Application Ref:	3/2026/0452			 Ribble Valley Borough Council www.ribblevalley.gov.uk
Date Inspected:	25/08/26	Site Notice:	25/08/26	
Officer:	LW			
DELEGATED ITEM FILE REPORT:				
				APPROVAL

Development Description:	Proposed change of use from retail to restaurant and bar.
Site Address/Location:	3a Swan Courtyard, Castle Street, Clitheroe, BB7 2DQ.

South West Elevation

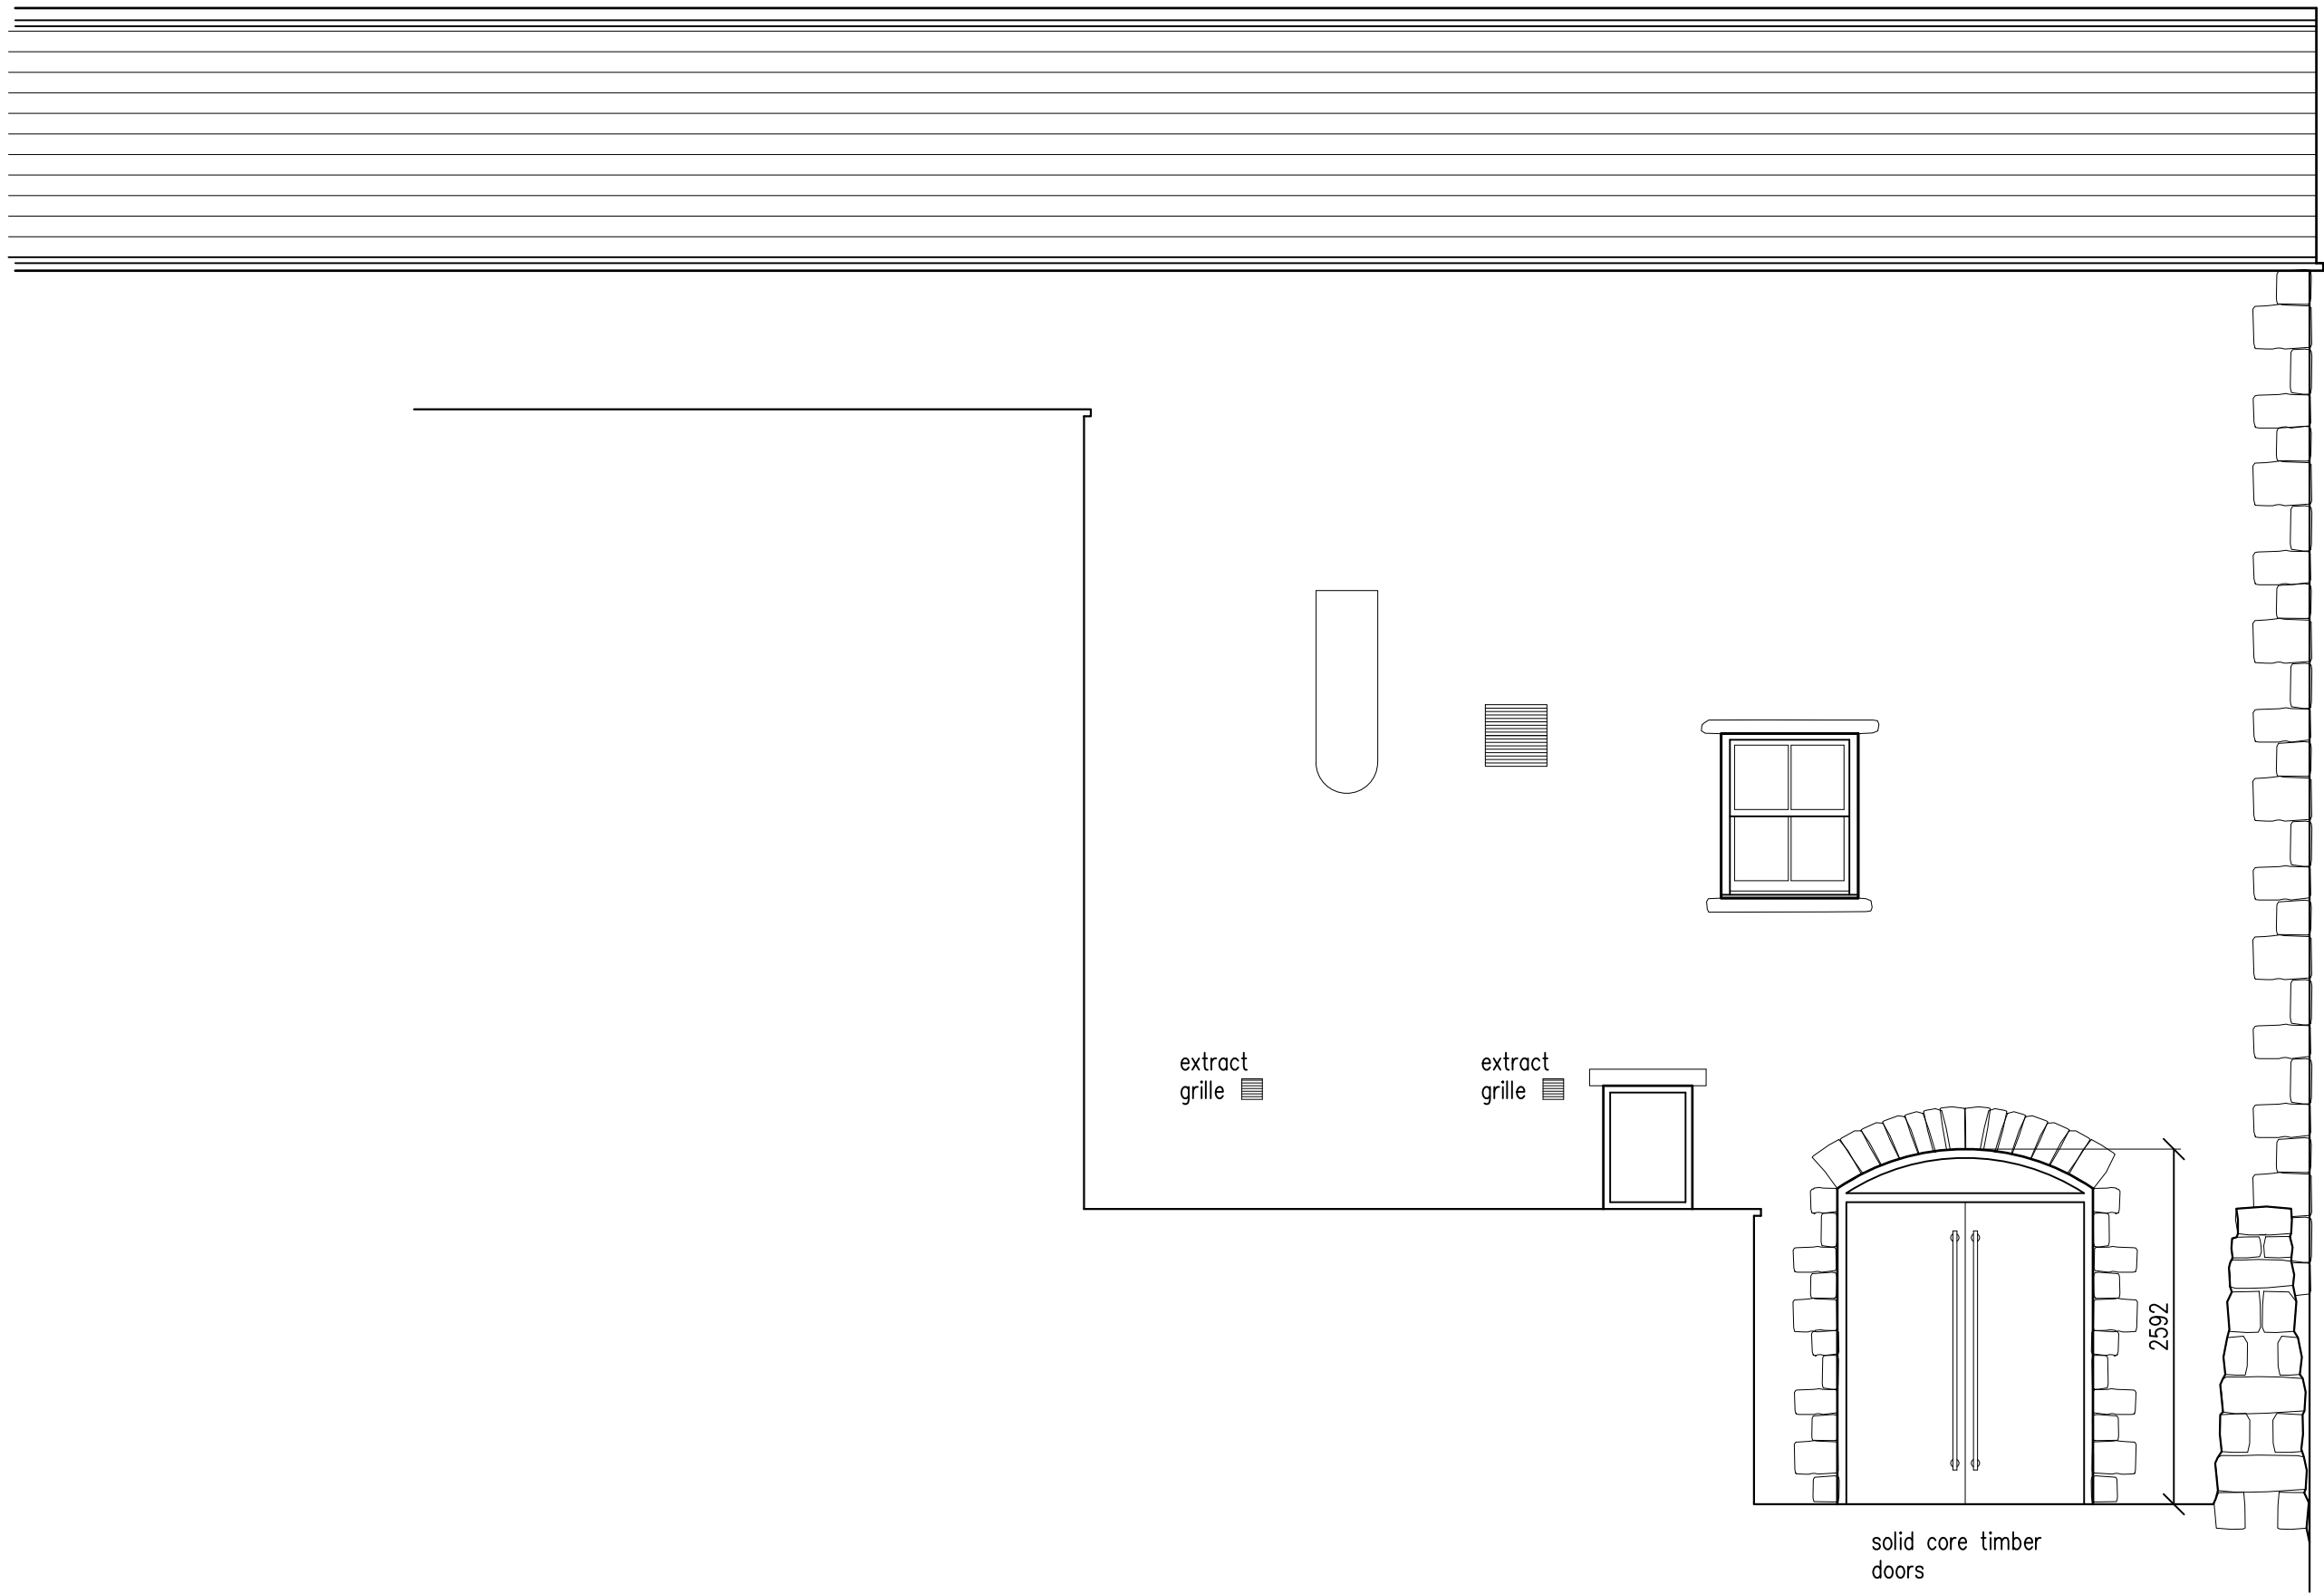
- The south-western elevation does not show the impact of external venting from the new toilets;
- The south-western elevation shows new doors placed in the existing archway leading up from Lowergate car park impacting public access;
- There are already plenty of bars and restaurants in Swan Courtyard and around Clitheroe;
- Proposal doesn't align with Clitheroe's desired atmosphere – drinking establishments discourage shoppers.

It is noted that a third-party representation raised concerns that the proposed extraction grilles were shown on the proposed floorplans but not the elevation drawings. An amended elevations plan has since been submitted which details the location and size of the grilles on the south-western elevation of the building showing these would be very modest additions to that elevation.

North East Elevation

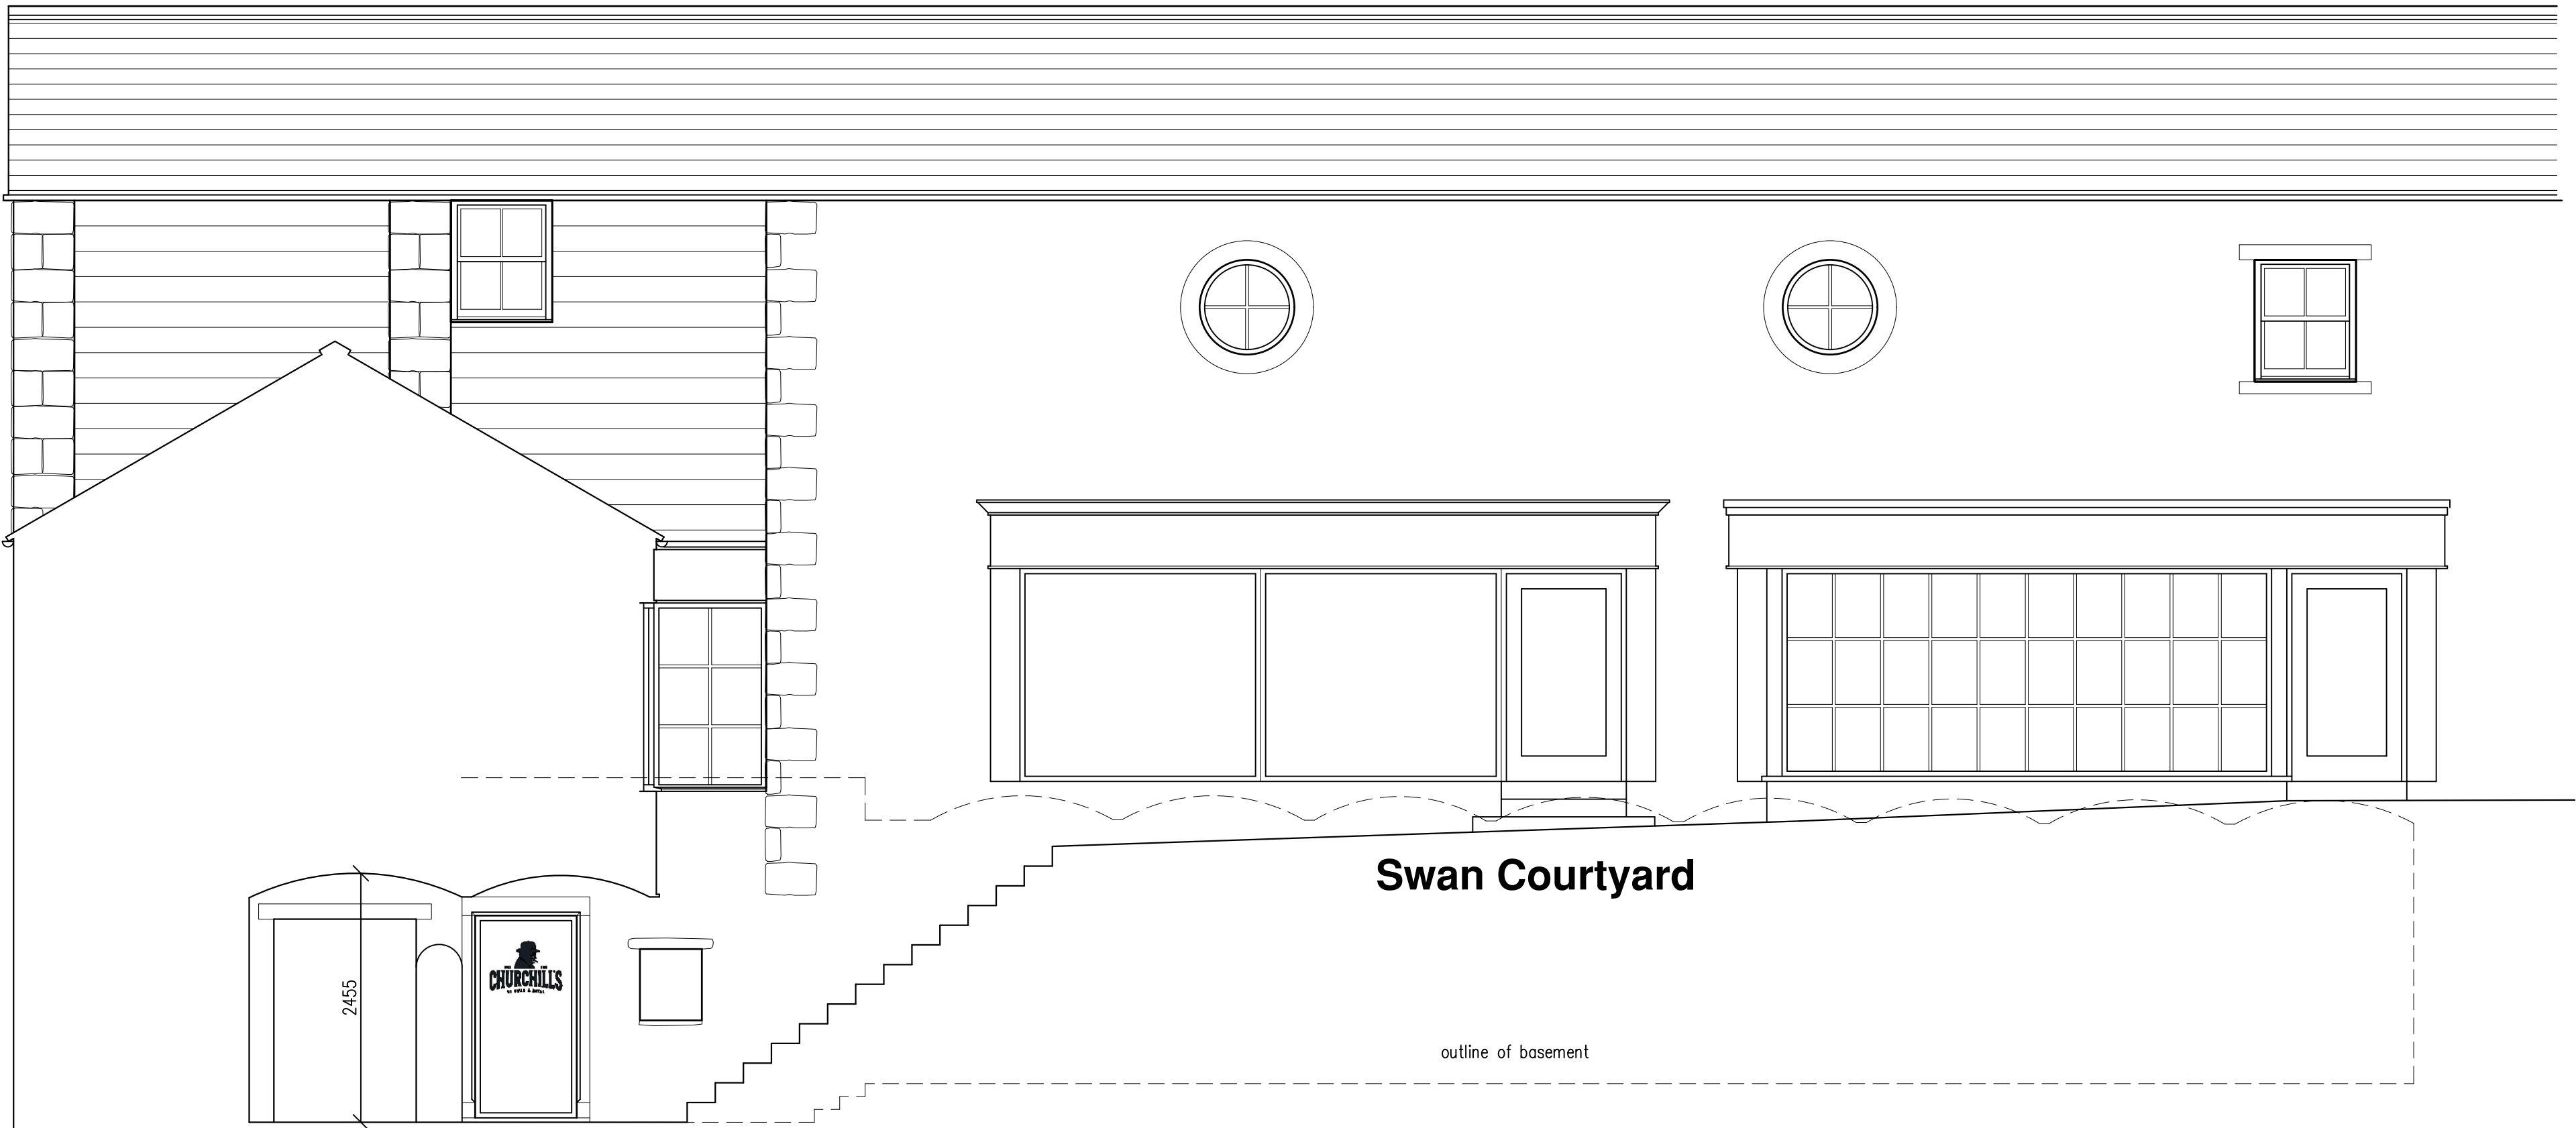
Concerns have been raised through third-party representations that the proposed doors at the entrance to the accessway from Lowergate car park would restrict public access between the car park and Swan Courtyard. However, this route does not constitute a definitive public right of way, and it is understood that the covered walkway is privately owned land. Accordingly, this matter does not weigh significantly against the proposal. The granting of planning permission would not override any covenants allowing public access rights across this private land, should they be in place, which would need to be pursued / resolved under separate legislation which sits outside of the planning process.
